Your Ref: AL/20/18/OUT

Our Ref: NW/ARU/18/07A

RE Land at Bridge Cottage and The Old Cottage London Road Lidsey PO22 9PH

Thank you for your correspondence of 24th May 2018, advising me of an Outline application with all matters reserved for the demolition of 2 No. dwellings & associated outbuildings & the erection of up to 27 No. dwellings, of which 30% will be affordable, with associated open space & access. This application is a Departure from the Development Plan which you seek advice from a crime prevention viewpoint.

Figure 4.1 – Illustrative Site Plan

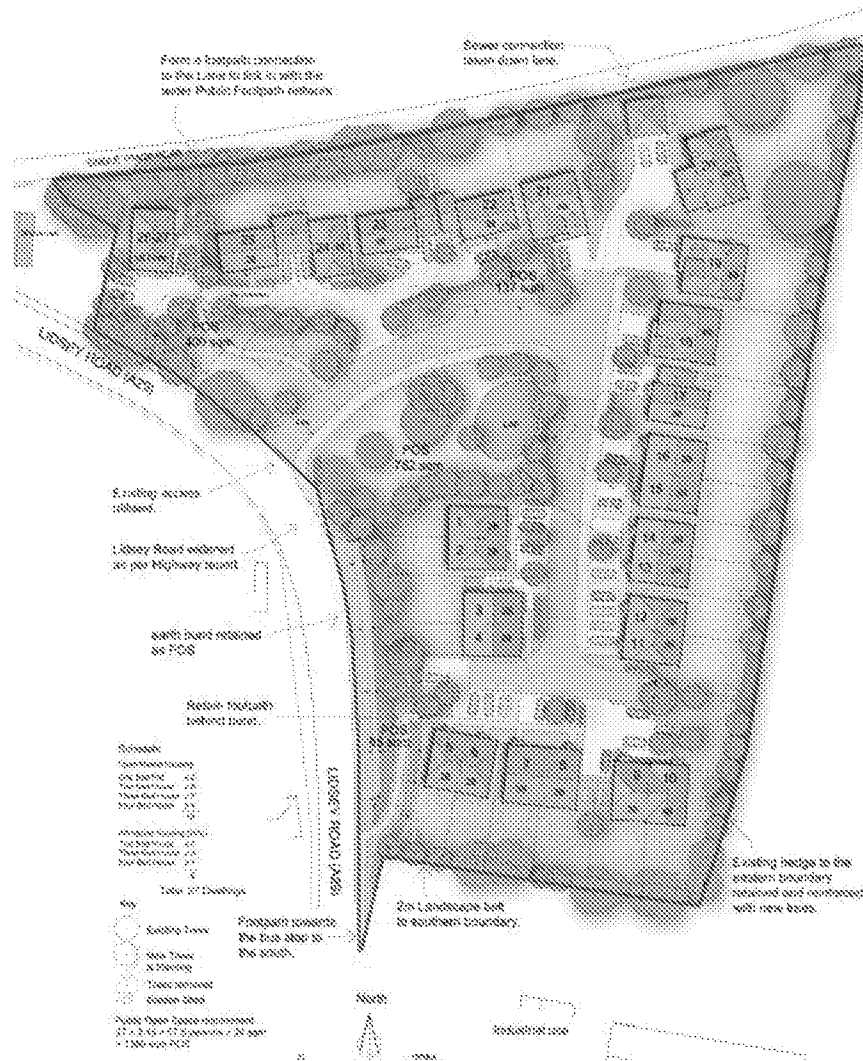
The development in the main has outward facing dwellings which has created good active frontage with the streets and the public areas being overlooked, this design has eliminated the need for vulnerable rear garden pathways. Parking in the main has been provided with in-curtilage and garage parking and a number of on street parking bays, this should leave the street layout free and unobstructed.

I am pleased to see cycle storage is available within garden sheds and garages. Further advice regarding cycle storage in shed is available within SBD 'Homes 2016' Chapter 53.

The public foot path leading to Lidsey Road bus stop alongside Plot 5 and 6 and adjacent to the Mission Hall plots 26-27 may make the side of the properties more vulnerable to unauthorised access from Lidsey Road.
